DECISION DELEGATED TO HEAD OF PLANNING

Application No: H23-0225-24 **Applicant:** Mr S Haynes

Proposal: Erection of single storey dwelling - outline approval of H23-0970-22 (Re-submission of H23-0797-23)

Location: Ravens Bank Whaplode St Catherine Spalding

Site Plan
Scale: 1:200

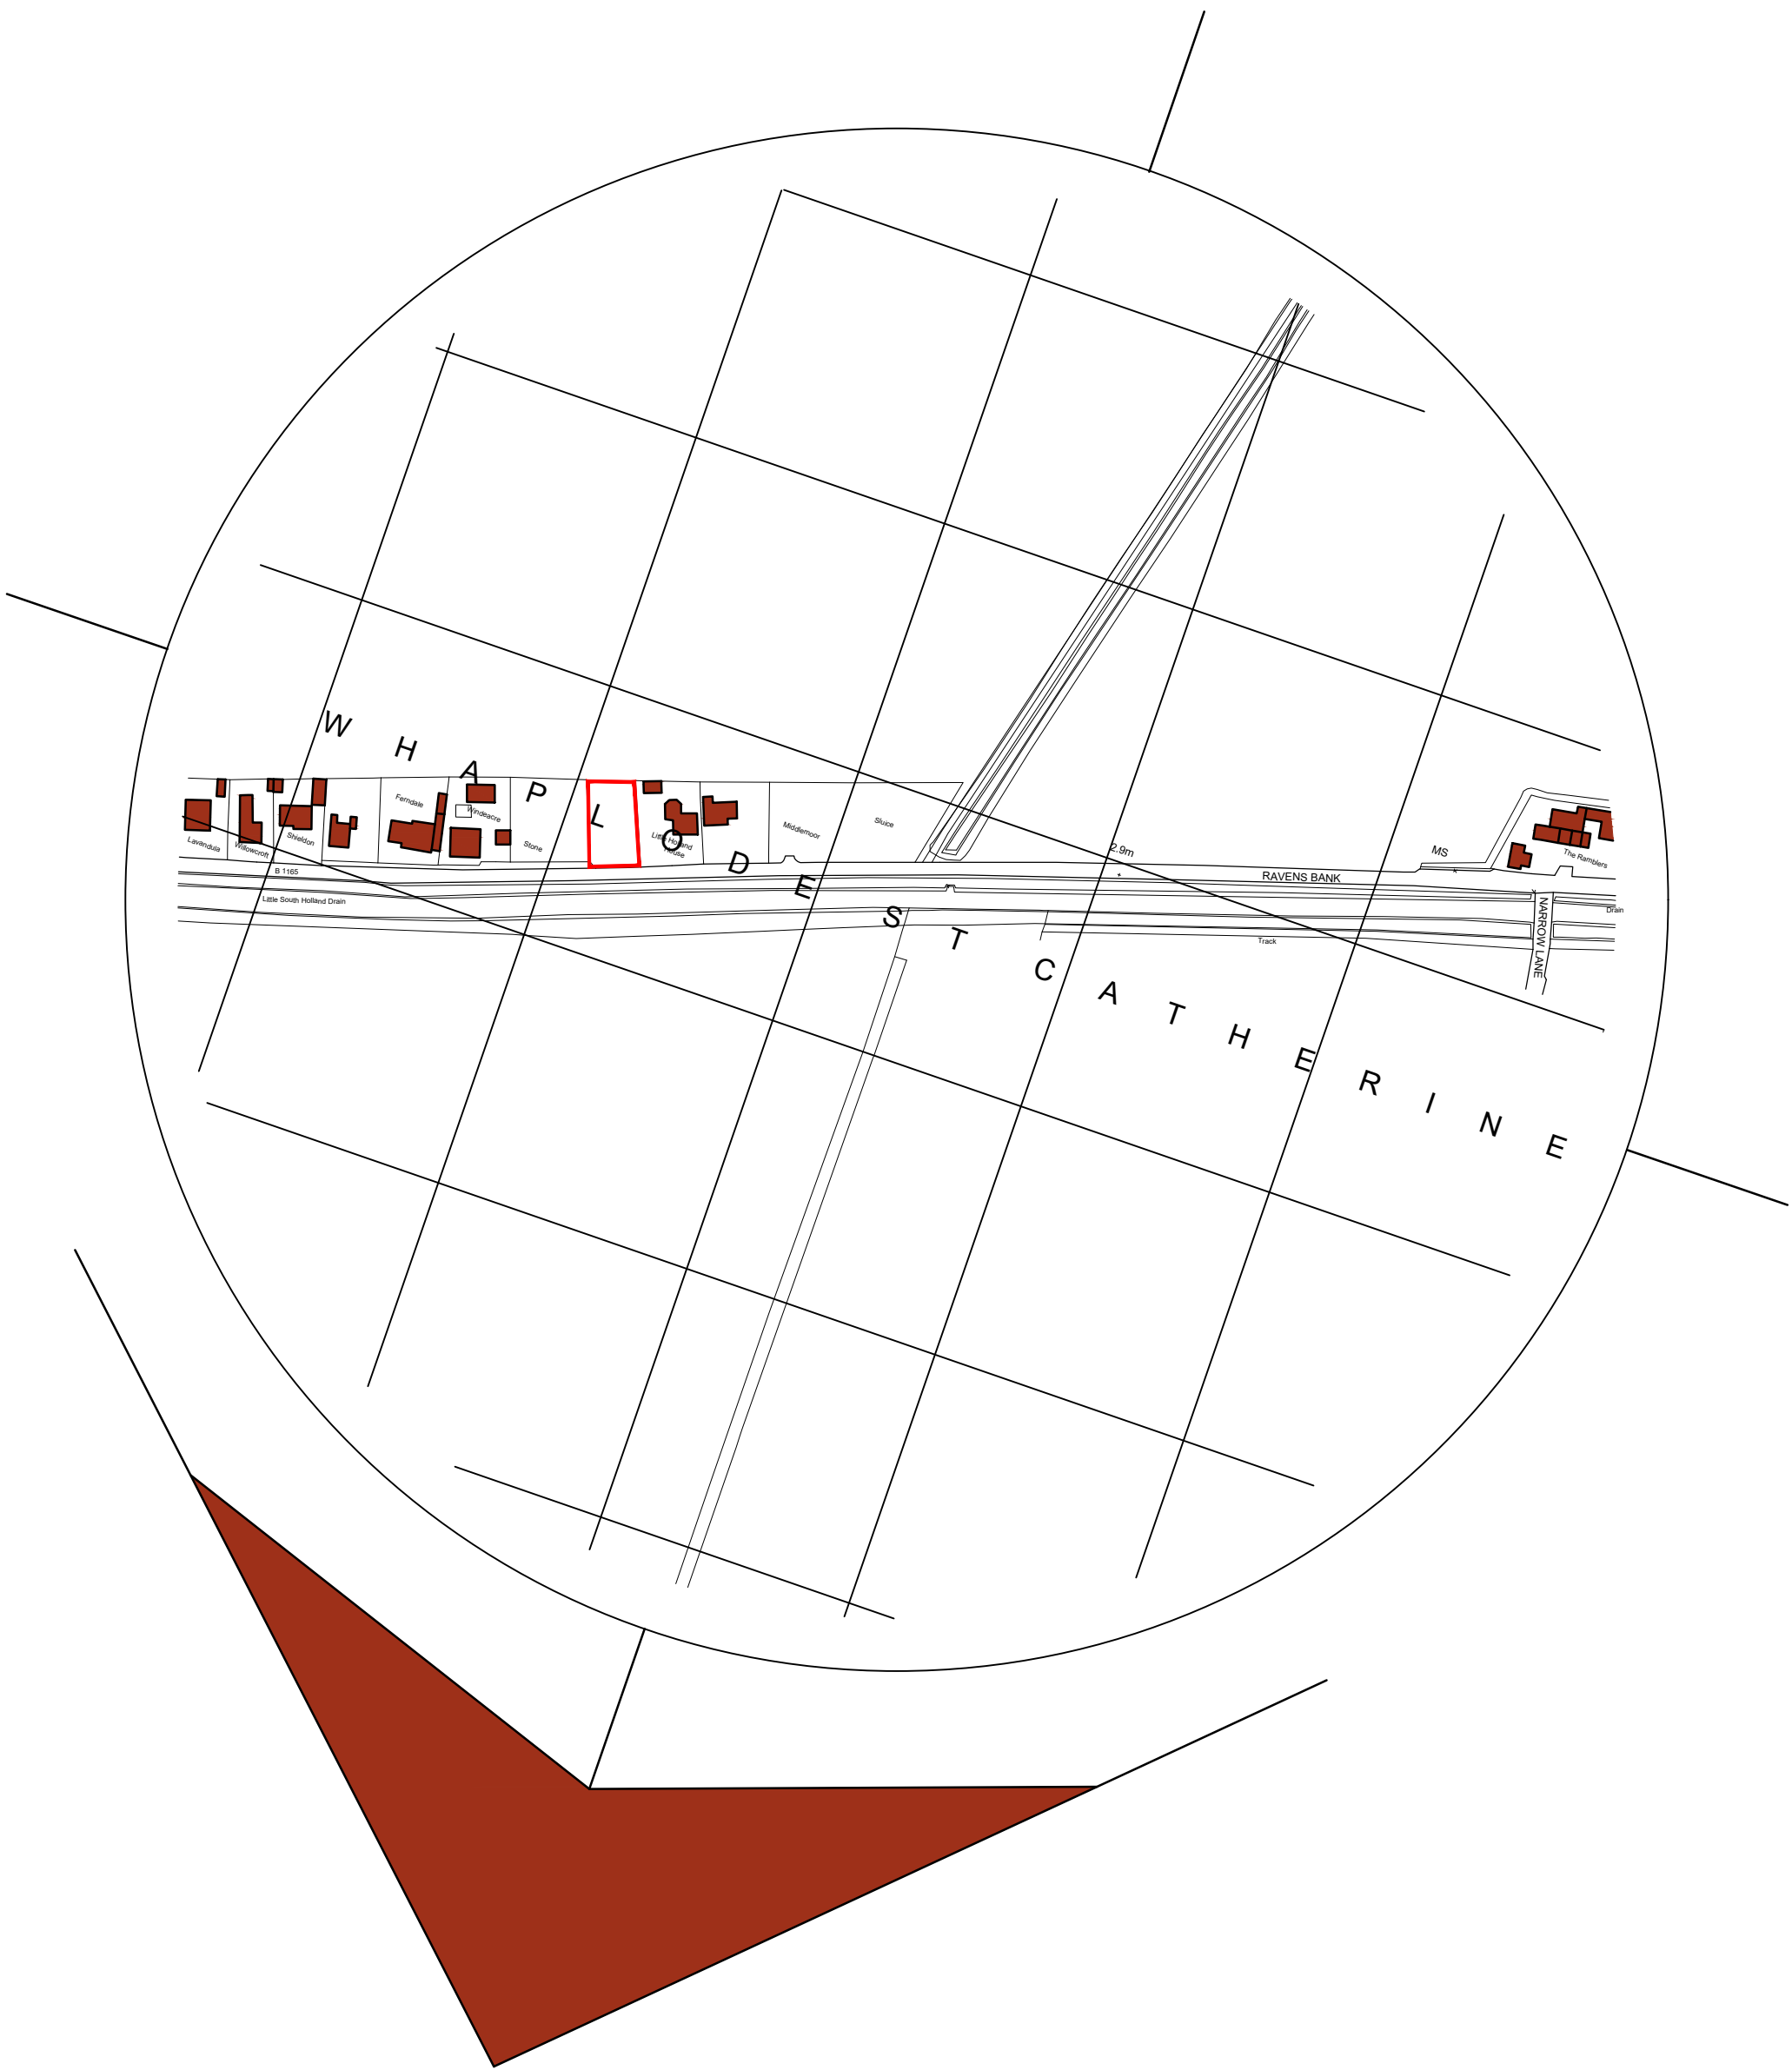
The proposal illustrates a new 1.8m fence to the eastern boundary, with the south and west boundary proposing a new 1.2m fence. These details must be submitted for approval by the Local Planning Authority through the outline Permission and as such, whilst these boundary details are considered to be acceptable, a further assessment and approval is required through a formal submission of details application. It is also noted that given the need for site levels to be submitted via condition of the outline approval, that the specific siting of these boundary treatments would also need to be provided within such future submission of details application.

It is noted that this reserved matters application illustrates that the finished floor levels of the site would be 150mm above 'road level'. However, details have not been provided that specifically outline the site levels of the road, the site levels of the existing application site or the site levels of the proposed development. Therefore, it is noted that the compliance with the recommendation of the Flood Risk Assessment is unknown.

Notwithstanding this, and the advice of the Local Planning Authority that the ground floor levels would need to be 300mm above the existing ground level, these details are required by condition attached to the outline approval to which this reserved matters application relates.

As such, the site levels and finished floor levels have not been approved or agreed within this application and the details of these must be submitted to the Local Planning Authority prior to the commencement of any development.
